# SOLACE APARTMENTS FILING NO. 2

### GALLEY RD. & PAONIA ST. - TRAFFIC SIGNAL PLANS

PCD NO: CDR-23-XXX ← CDR2311

SOLACE APARTMENTS FILING NO. 2
CONSTRUCTION DOCUMENTS
GALLEY RD & PAONIA ST - TRAFFIC SIGNAL PLANS
SIGNAGE AND STRIPING PLAN

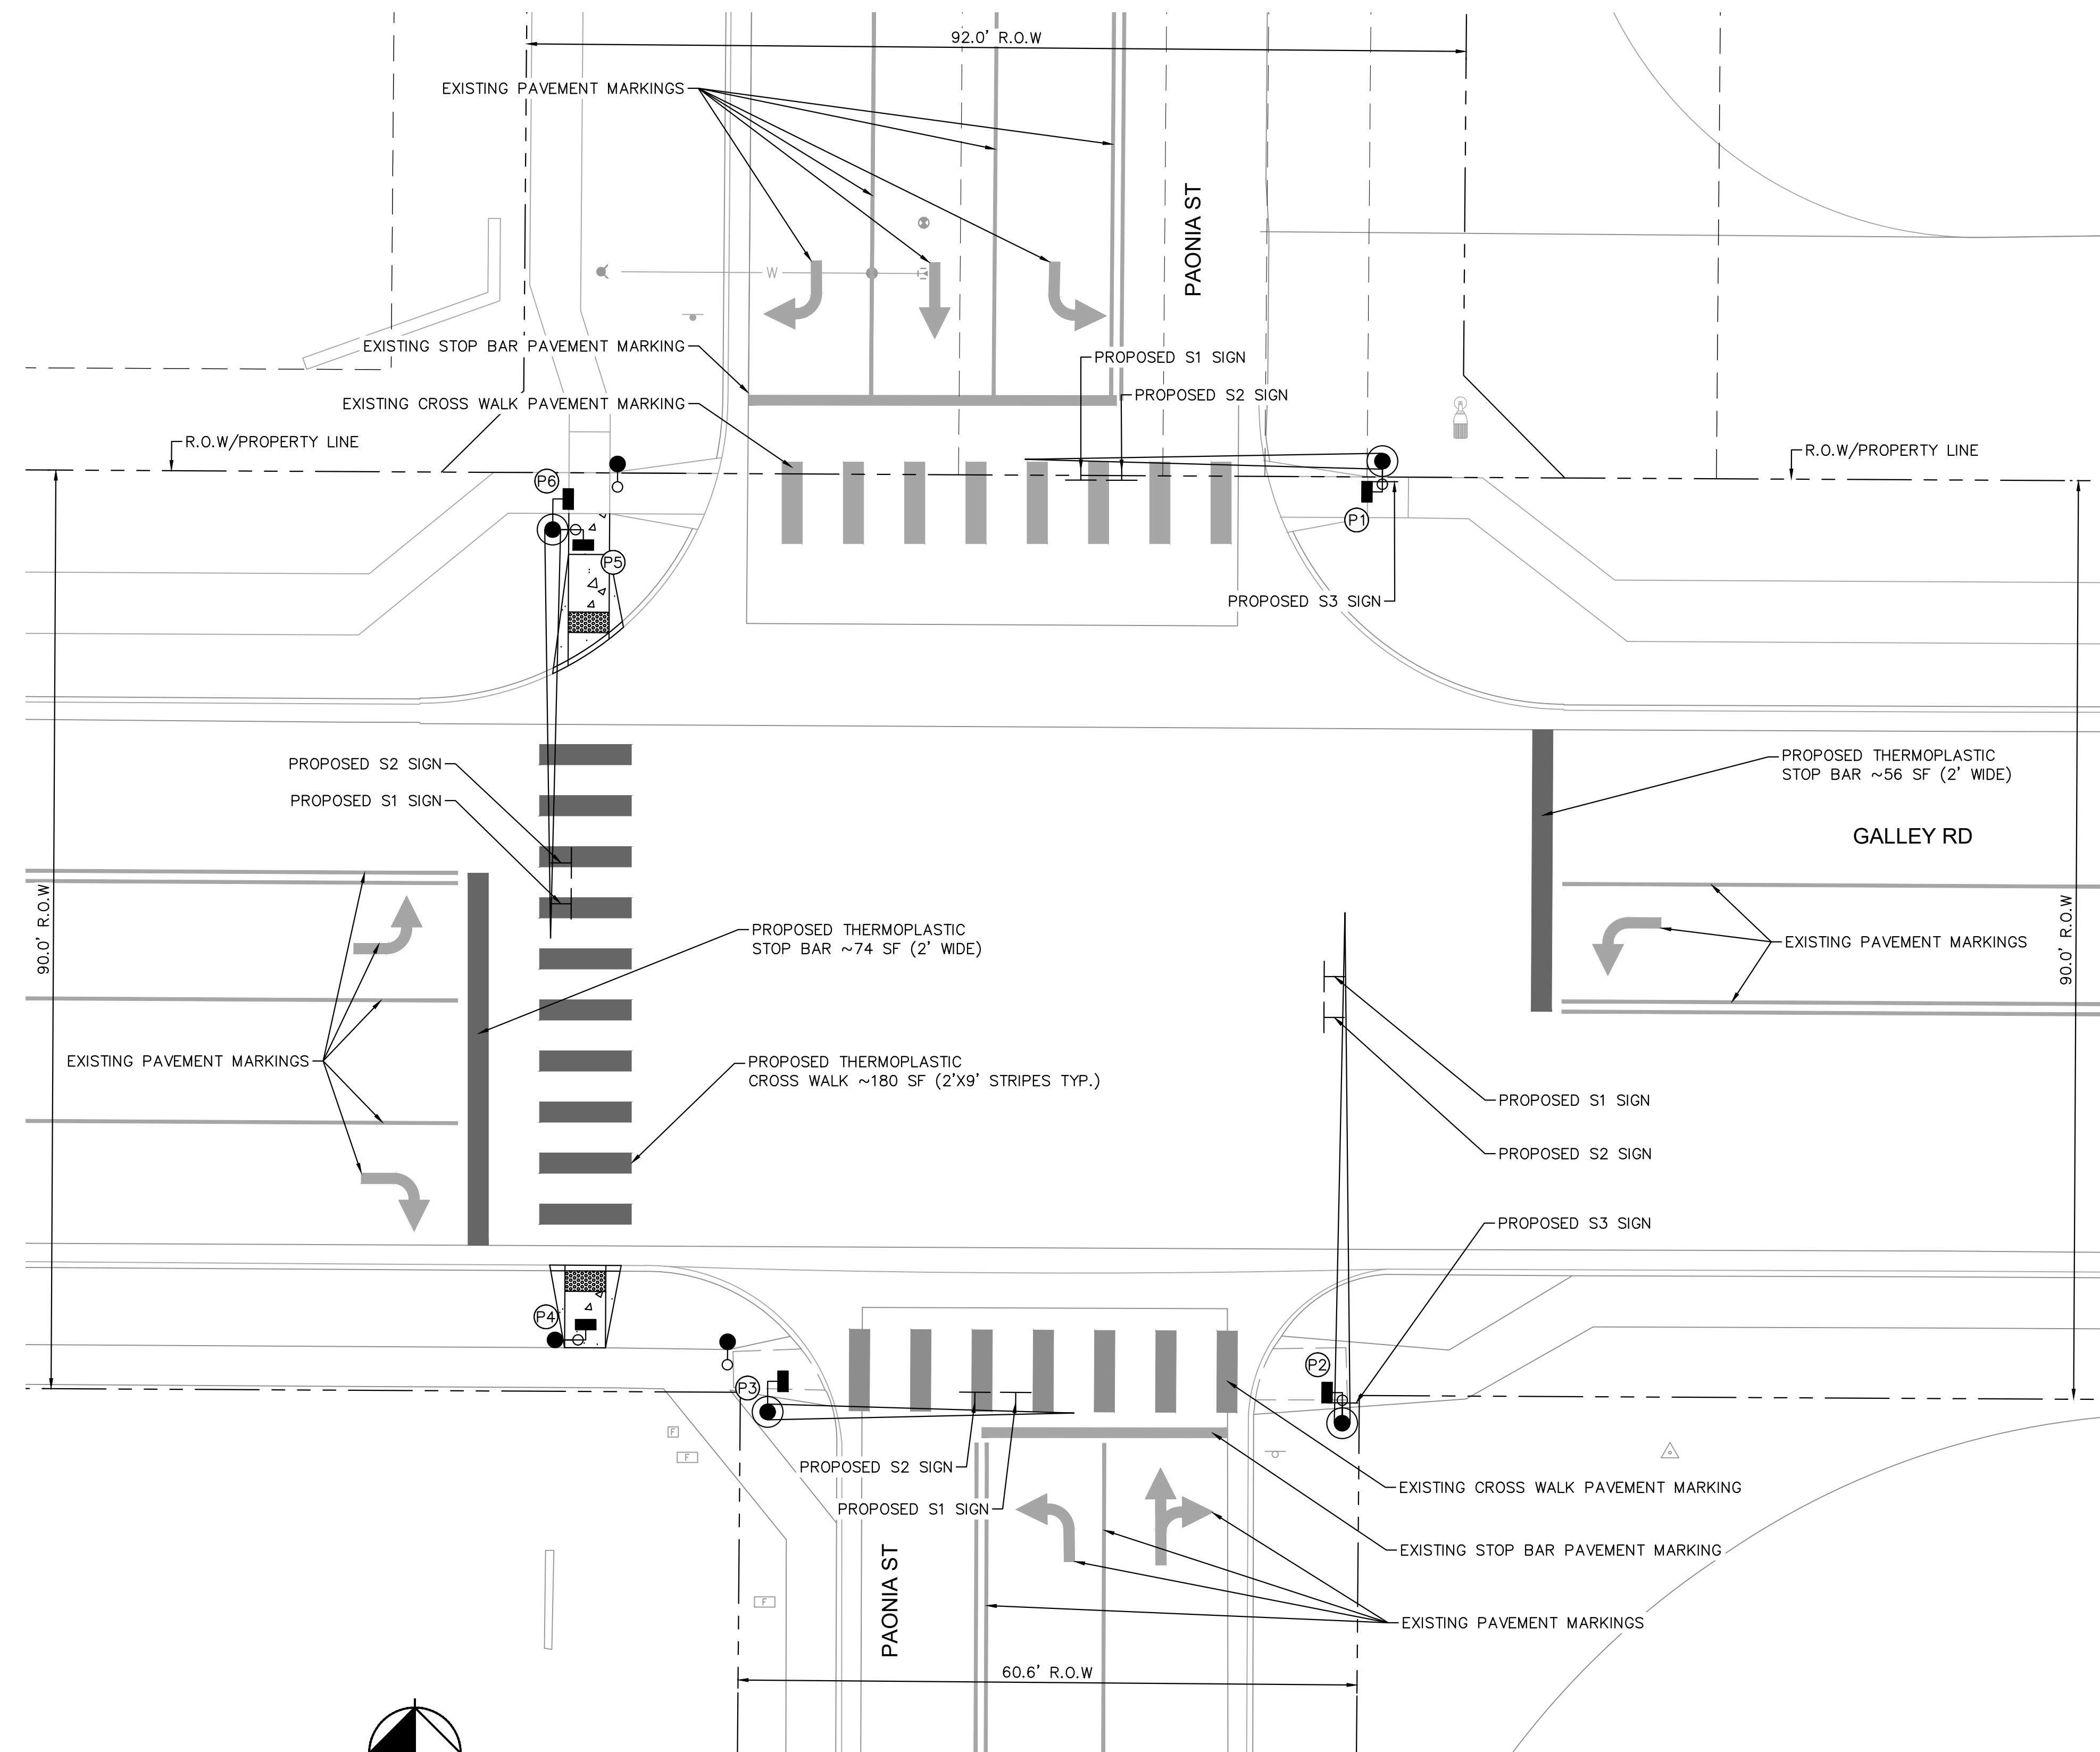
Provide size of each sign (2'x?). Refer to attached specs. above.

GALLEY RD & PAONIA ST - TRAFFIC SIGNAL PLANS
CONDUIT PLAN

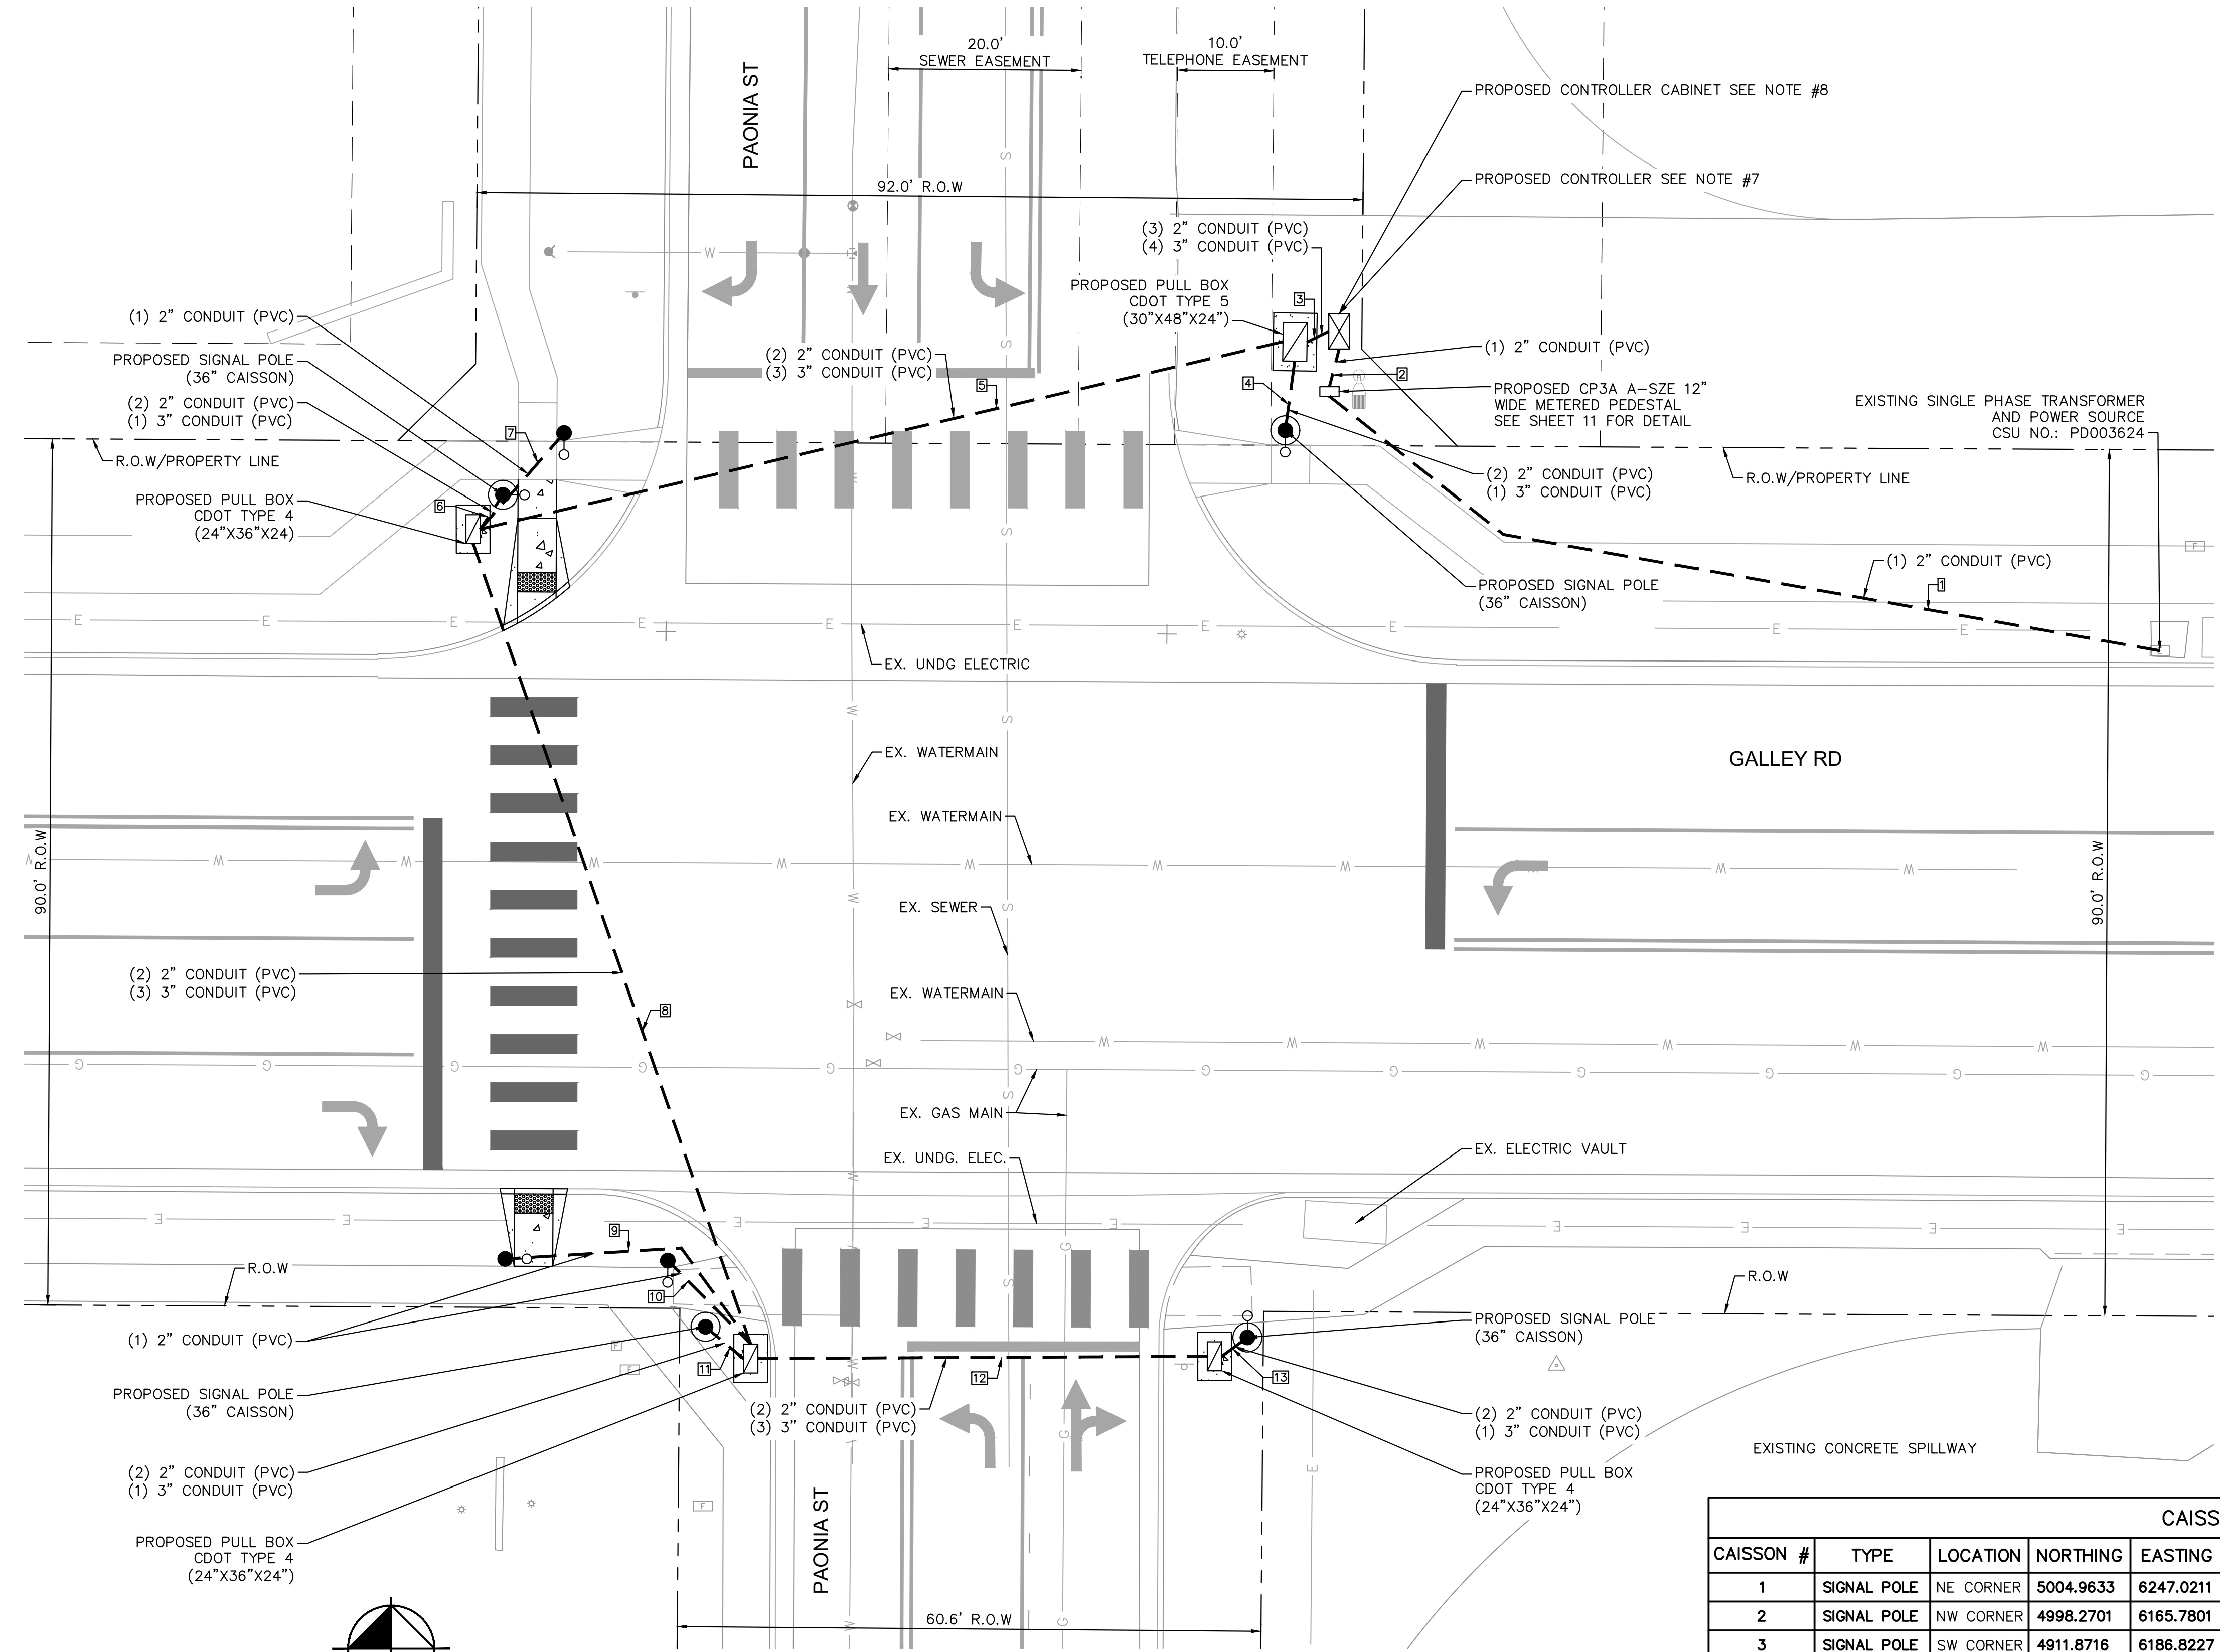
update all number of conduits to match what is listed in note #26 of the attached traffic signal notes on sheet 3
